Shoreline Exemption SX-19-00012

The Shoreline Exemption Permit application submitted on August 22, 2019 has been deemed **incomplete**. Please provide to following required information for continued processing your application.

Gregon PWS, Set-up

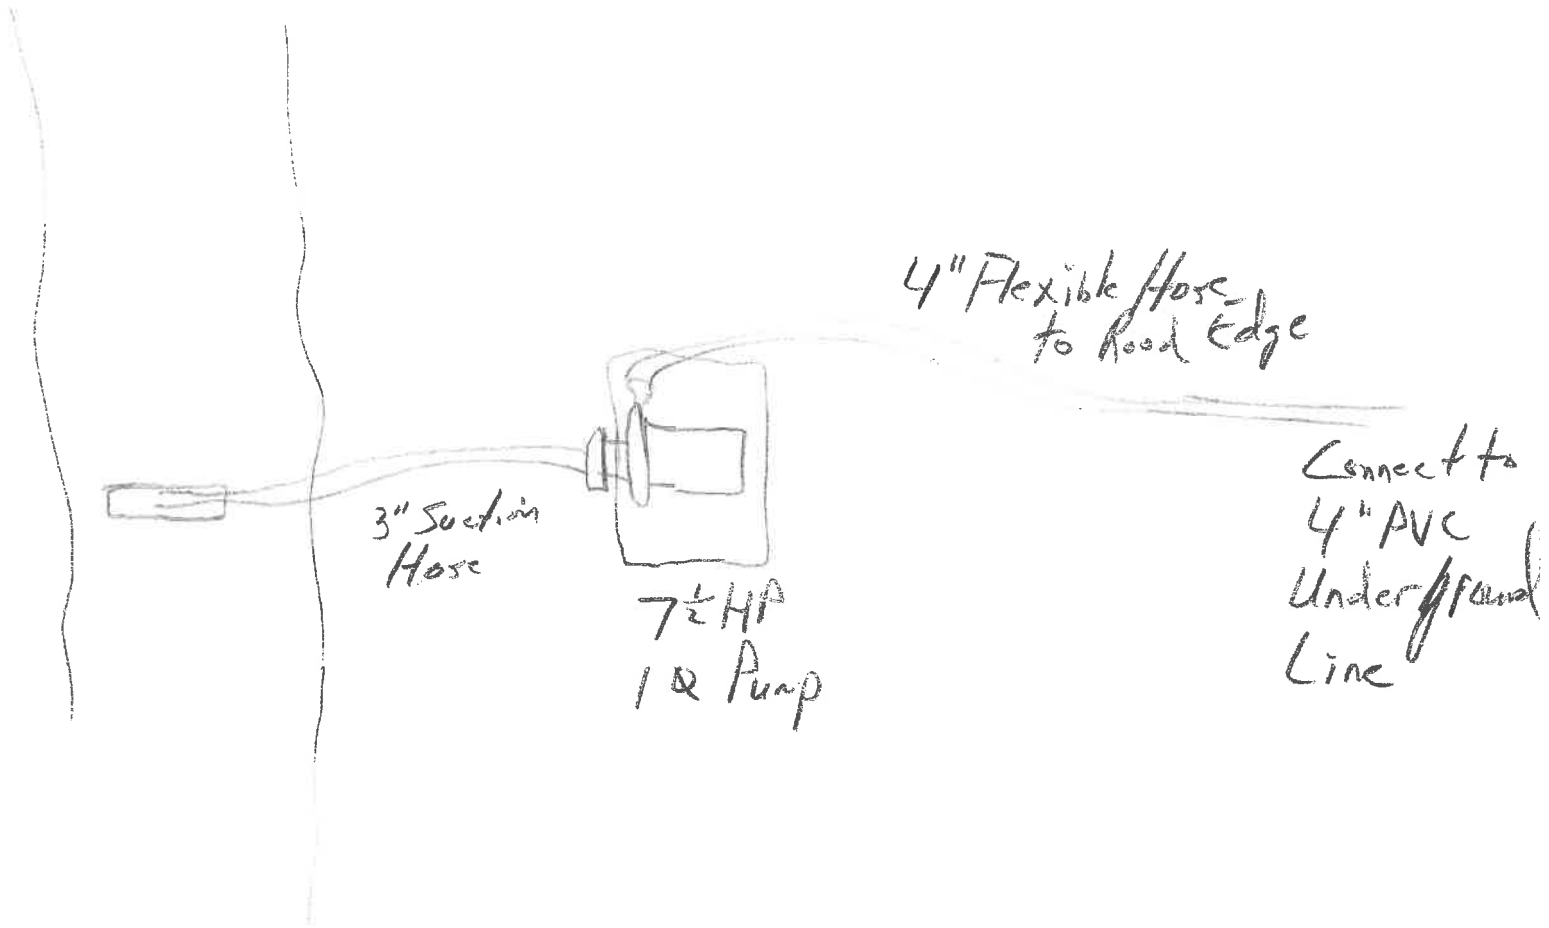
1. Update Site plan (Pump Set Up) to include the elements listed below:
 - Project dimensions
 - Drawn to scale
2. Signature of owner or estate representative for parcel number 248233.
